WEST SUSSEX COUNTY COUNCIL CONSULTATION

TO:	Arun District Council FAO: Harry Chalk
FROM:	Highways, WSCC
DATE:	16/04/2025
LOCATION:	10 Nelson Road, Bognor Regis, PO21 2RY
SUBJECT:	BR/47/25/PL Demolition of existing garage and erection of 1 No 2-bed chalet bungalow (self build), close up existing gateway and addition of new gateway. This application is in CIL Zone 4 and is CIL Liable as a new dwelling.
DATE OF SITE VISIT:	N/A
RECOMMENDATION:	Advice
S106 CONTRIBUTION TOTAL:	N/A

Proposed Site + Roof Plan

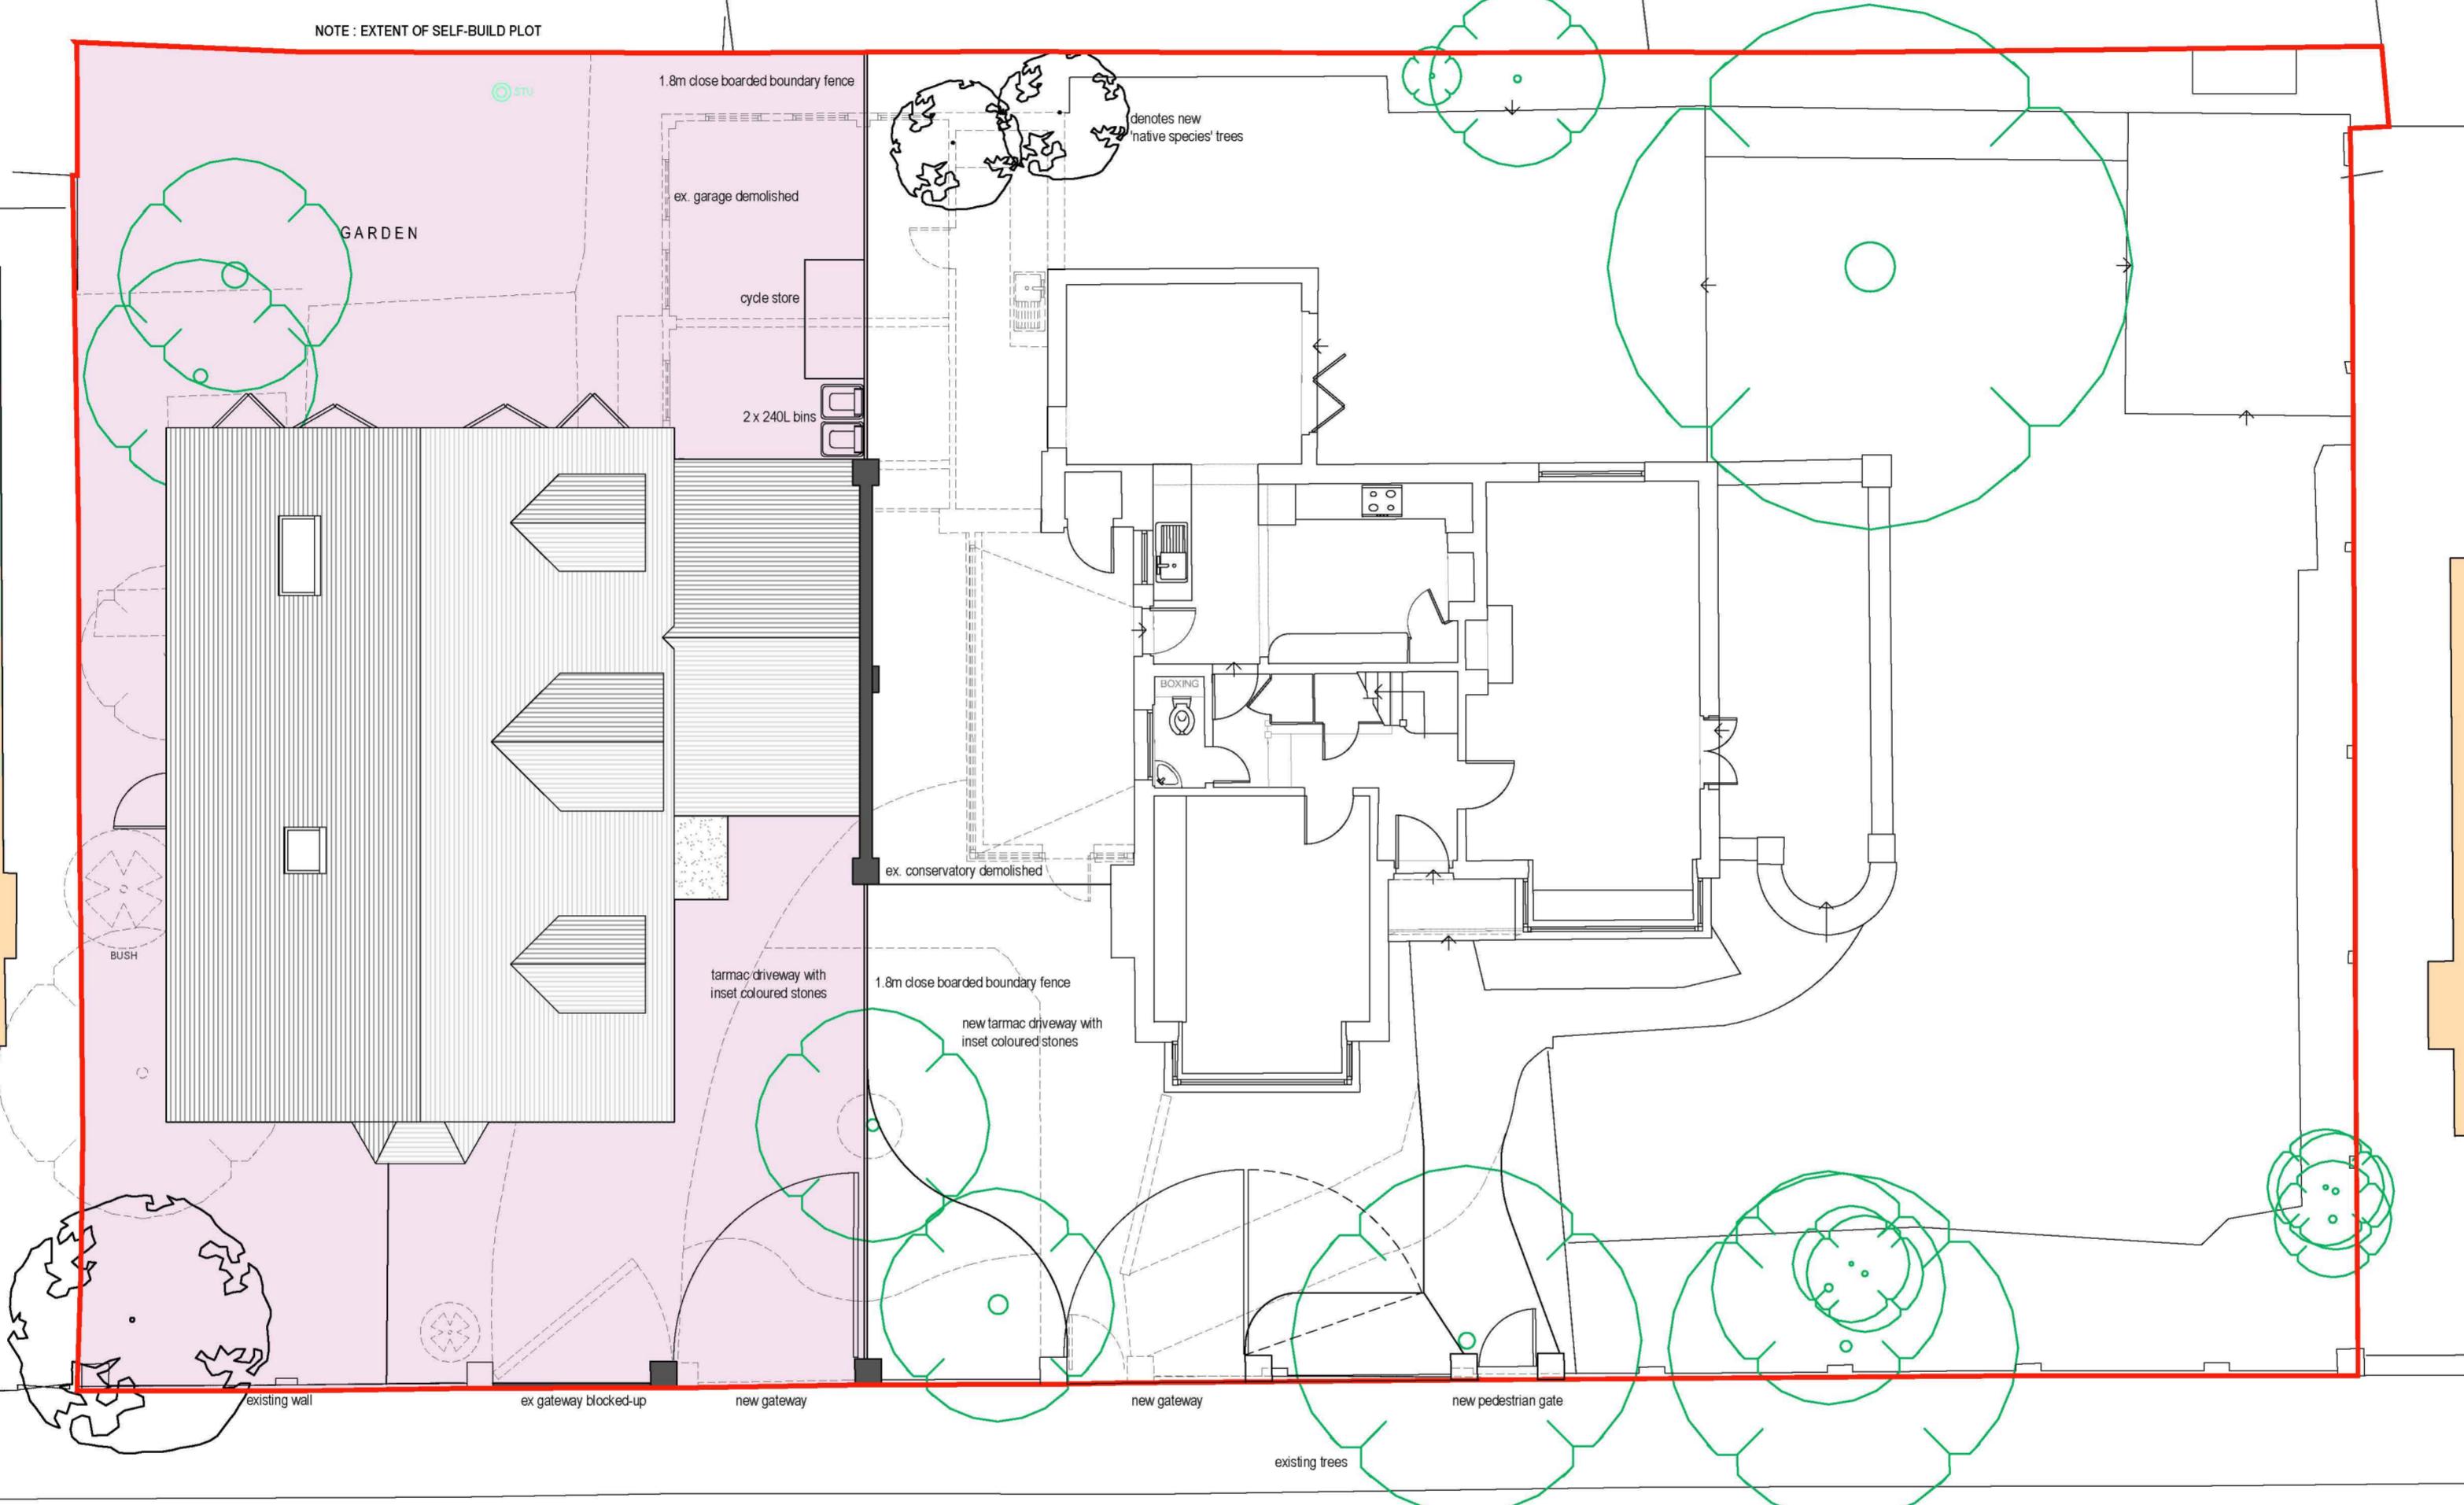
New 4m wide vehicular access points are proposed for both existing and proposed dwellings. From inspection of the submitted visibility splay plan and WSCC mapping, visibility appears sufficient in both directions for both proposed access points. The proposed access works will be subject to a licence obtained through the local WSCC Highway Area Office and constructed to a specification agreed with the local WSCC Highway Area Engineer.

Regarding parking, the proposed dwelling will be provided with a driveway and carport, and this appears of suitable size to provide off-street car parking provision in accordance with Arun Parking Standards. On-site turning does not appear achievable, so cars may have to exit in a reverse gear – however, this is not anticipated to give rise to an adverse highway safety impact, owing to good forward visibility in this location.

The site is situated in a sustainable location within walking/cycle distance of local services, amenities and public transport connections. Cycling is a viable option in the local area, and provision for the secure storage of bicycles has been demonstrated.

Car parking space (details approved)

No part of the development shall be first occupied until the car parking has been constructed in accordance with the approved site plan. These spaces shall thereafter be retained at all times for their designated purpose.

Cycle parking

No part of the development shall be first occupied until covered and secure cycle parking spaces have been provided in accordance with plans and details to be submitted to and approved by the Local Planning Authority.
